Application No: R/63/22/CLP
Site Address: 31 Broadmark Lane Rustington BN16 2HD
Description of works: Lawful development certificate for a proposed loft conversion including dormer extension to the rear of the property.

Thank you for your internet representation made on 21st April 2022 which has been recorded as an objection with the comments as follows:

Proposed Rear Elevation 1:100 @ A3

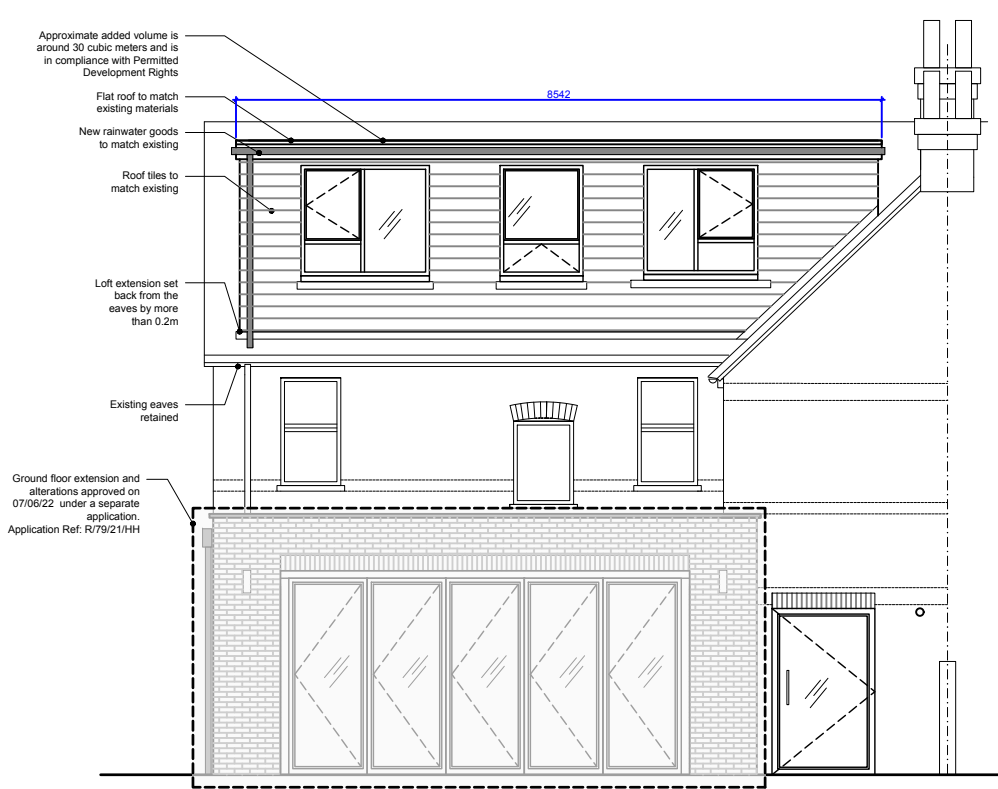
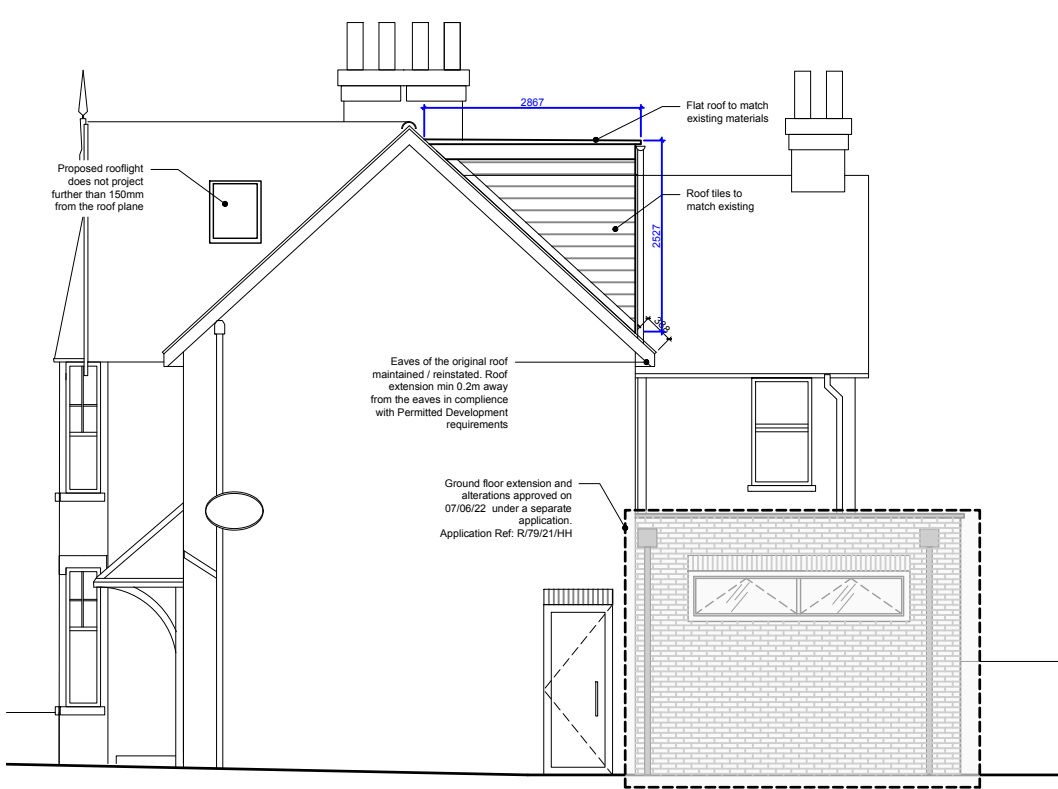
We do not object to the loft conversion but do have serious concerns about the size of the dormer and the amount of large windows.

We will have an additional 3 windows overlooking us which are a lot larger than the existing rear windows on the property.

We currently have a 100% privacy in our garden, which we would lose if this development is permitted to proceed according to the plans.

We also have concerns with the extra shadowing on our garden due to the orientation of our properties.
